Bicester Gateway Phase 1b RMA

Response to OCC Comments on Application

Project: 226701

By: FC / Date: 22/09/22

STATUS: INFORMATION ONLY

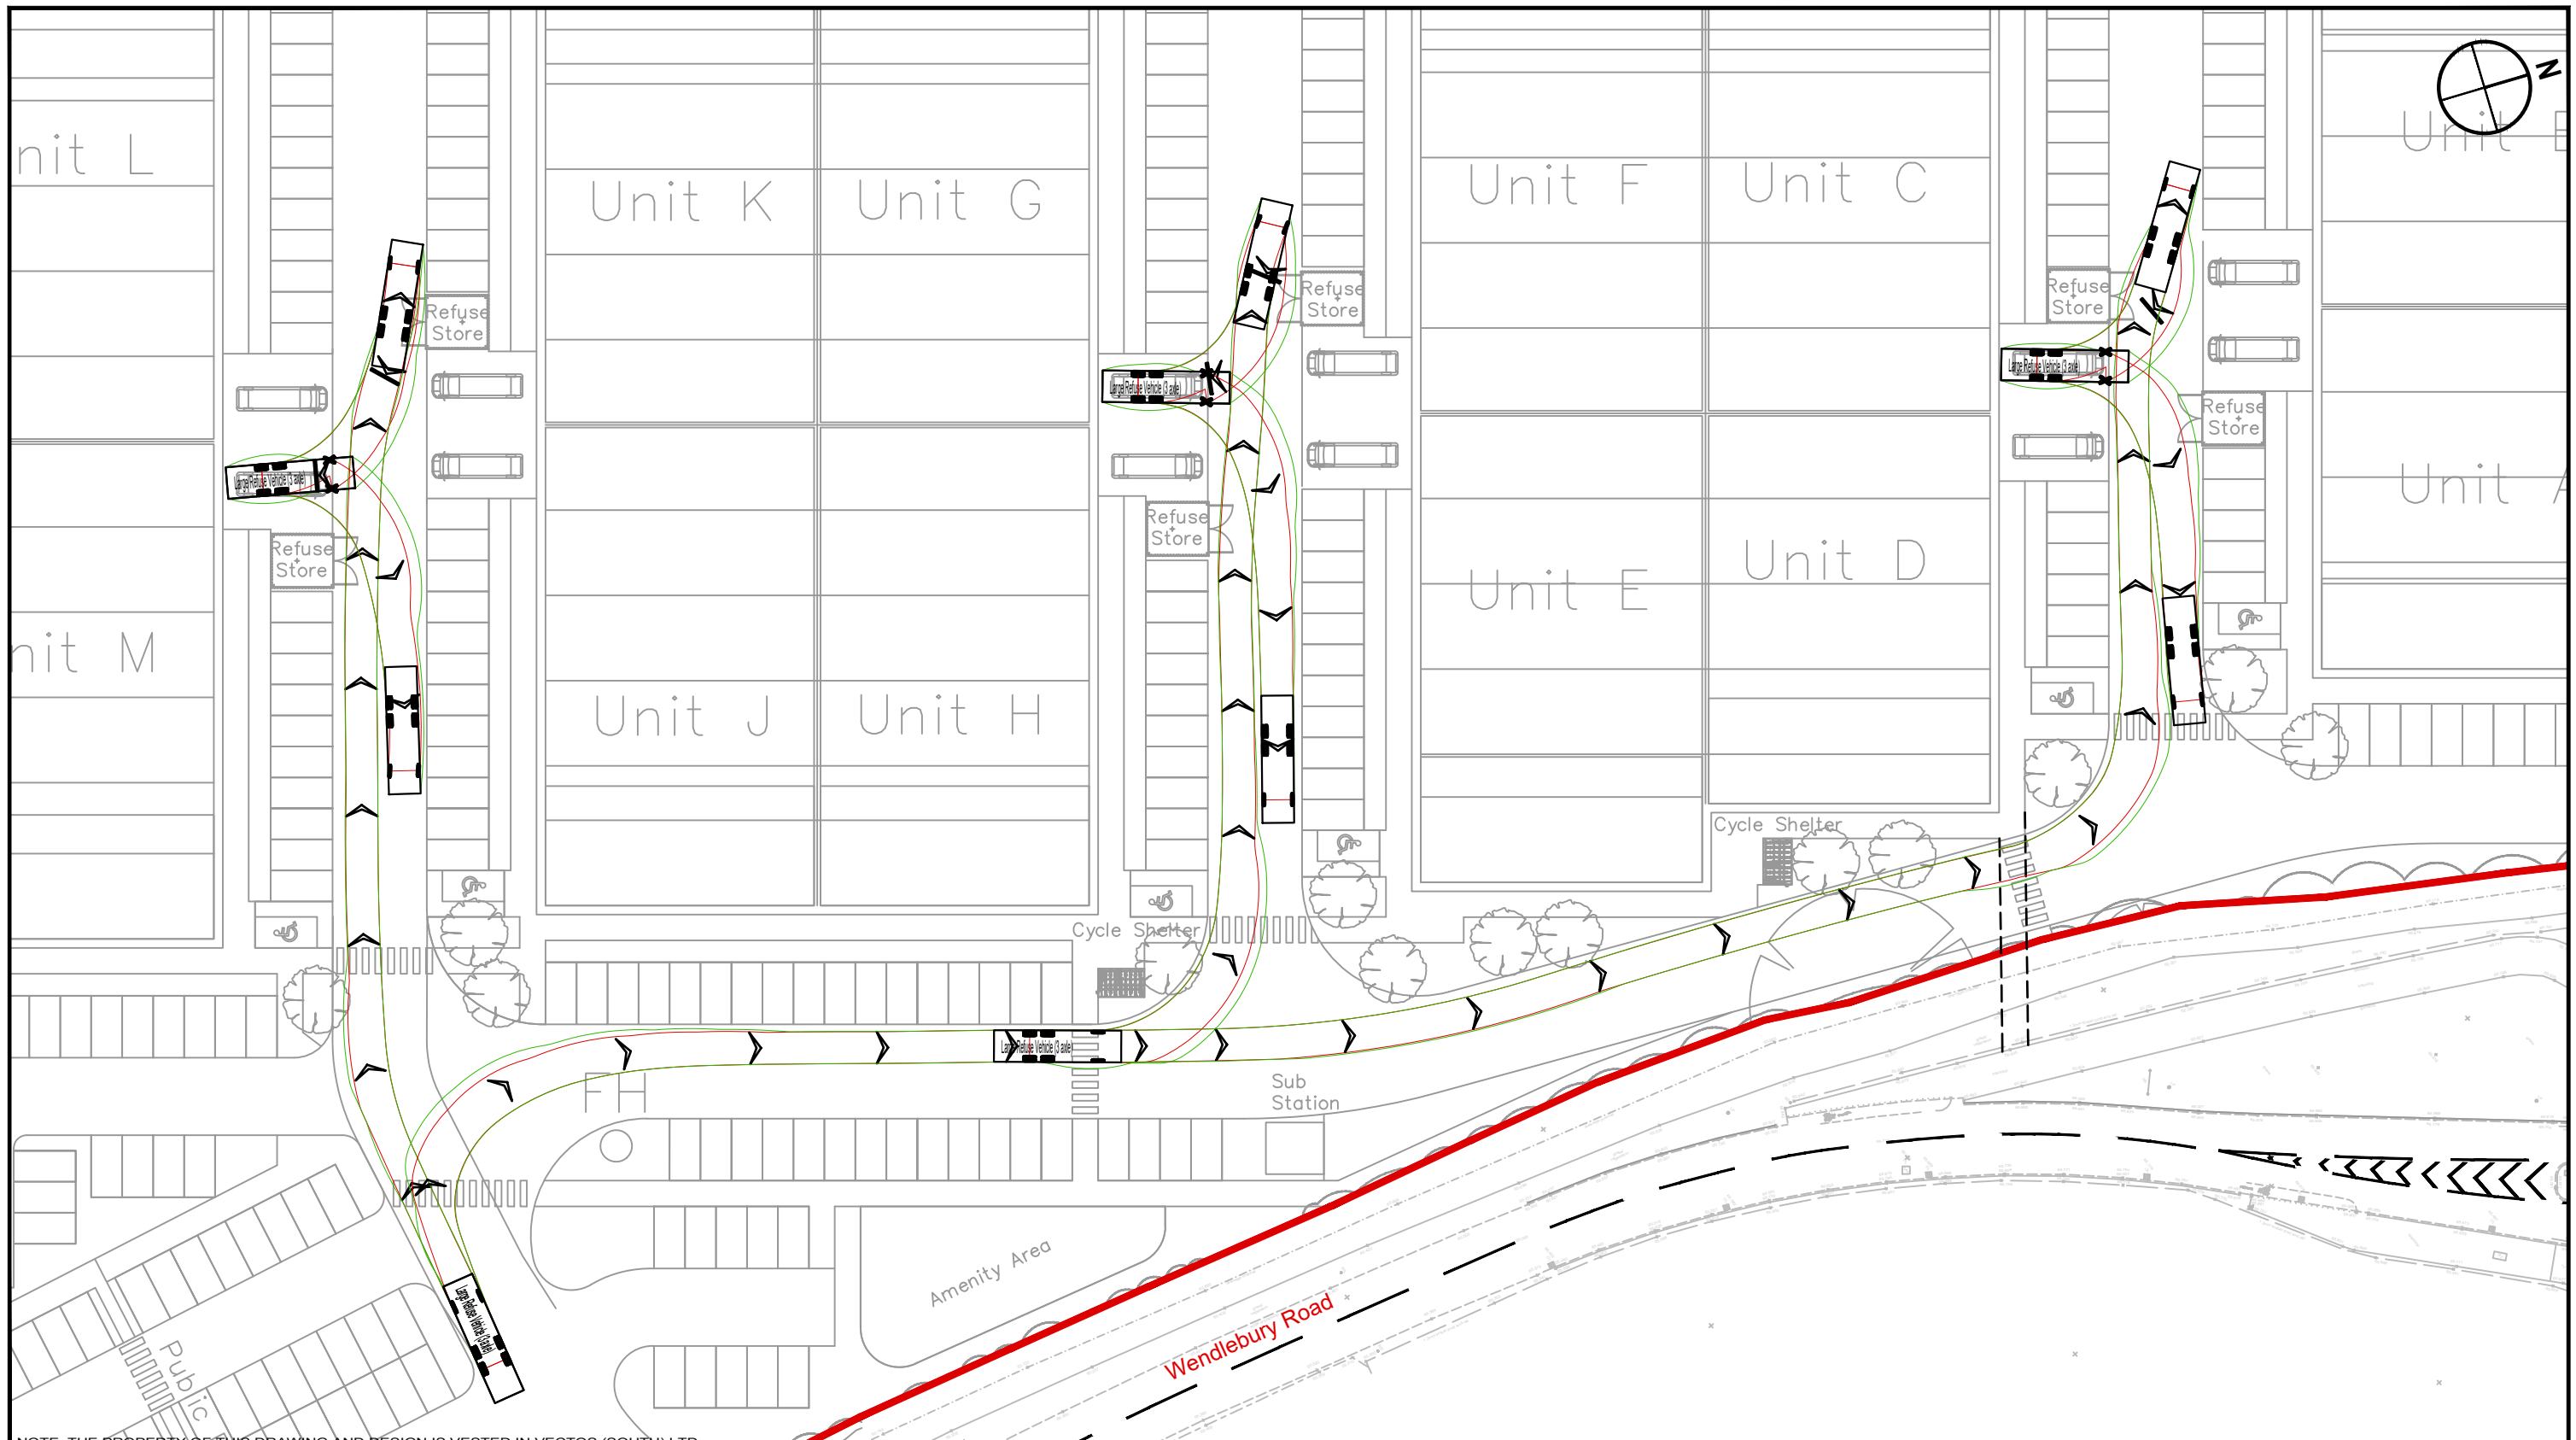
HGV tracking should be provided for entrance and exit of site. **Reason for objection.**

31. Drawings providing vehicle swept path analysis for a box van, a refuse vehicle, a 12m flat-bed lorry, and an articulated lorry are provided in the Transport Statement accompanying the Reserved Matters Application, in Appendix F. These drawings demonstrate that the proposed development can be accessed by a range of servicing vehicles to meet the requirements of prospective tenants on site. There is no need to provide this information again.
